Harnett County

Permit Number: BCOM2306-0003

Description: **Popeyes Restaurant**

Site Address: **1517 NC 24-87**

Drawing Title: LIFE SAFETY & EXITING PLAN

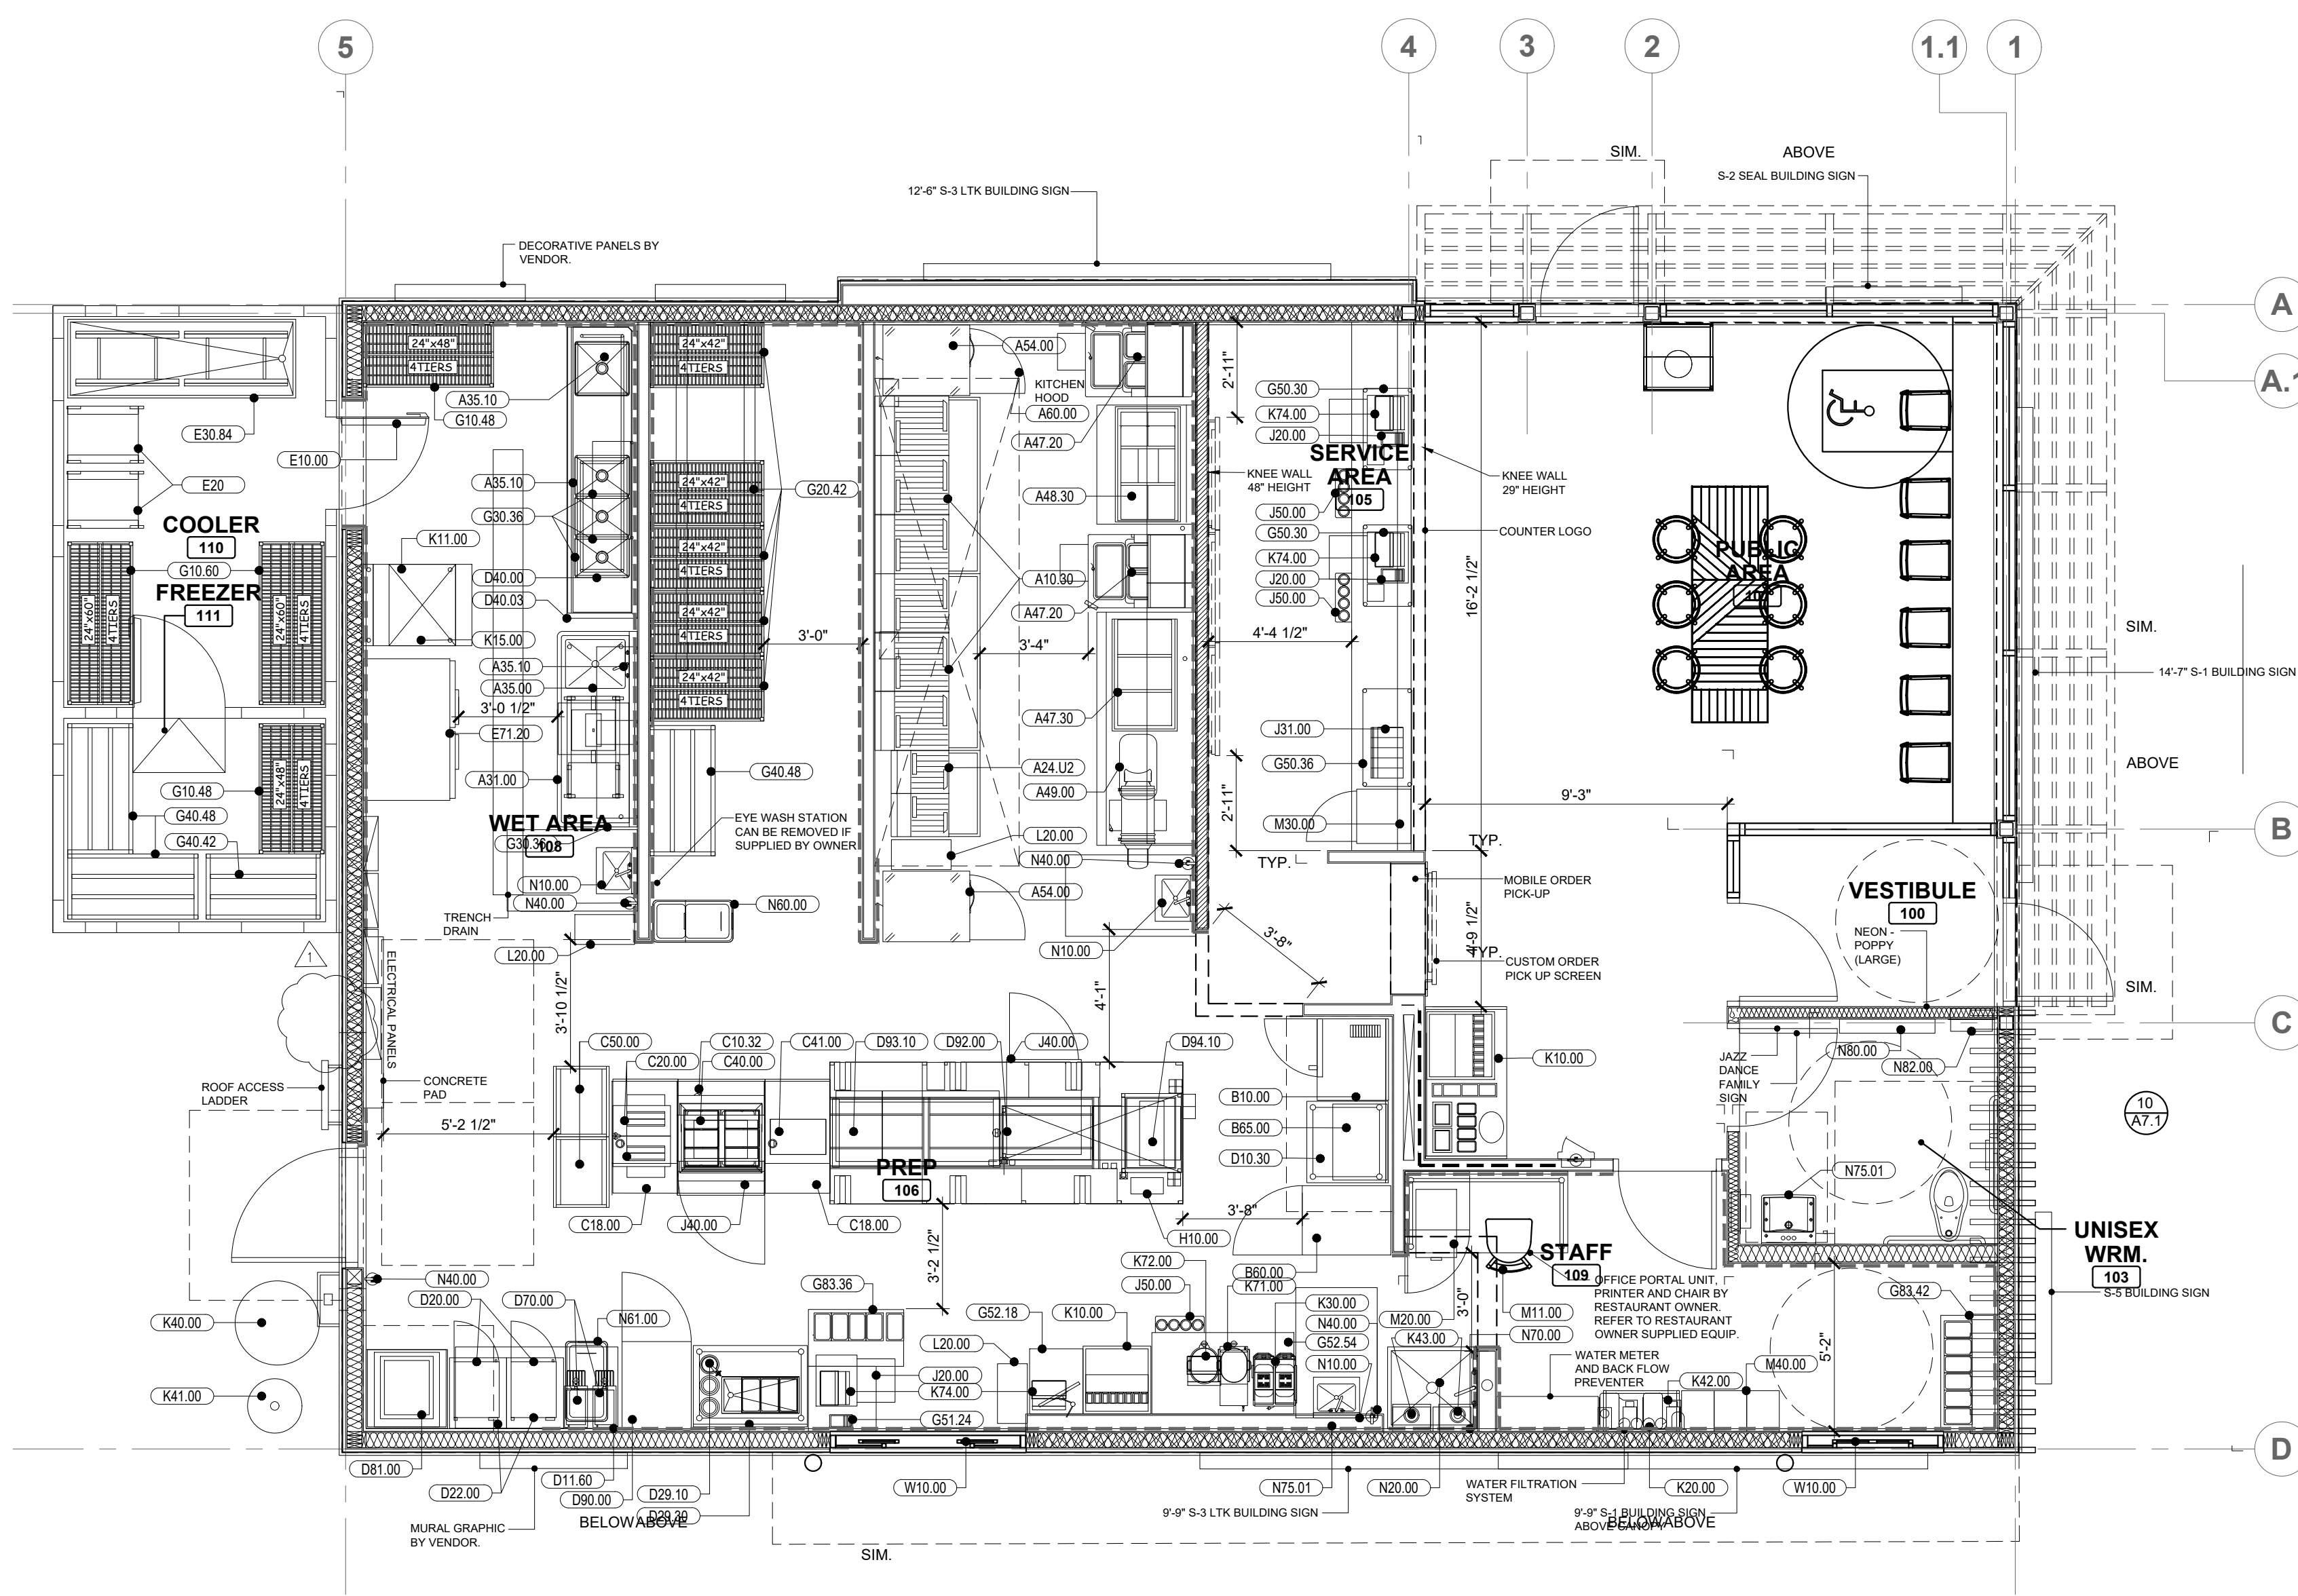
1. Response letter states Appendix B submitted. Still do not have NC format Appendix B. This will include energy information (zone 4) that will effect all building and mechanical systems.
2. Occupant load calculated is 33. Only 1 restroom shown in building
3. Provide shunt trip information for all electric cooking equipment under hood systems. Cooking equipment is spread across different panels.
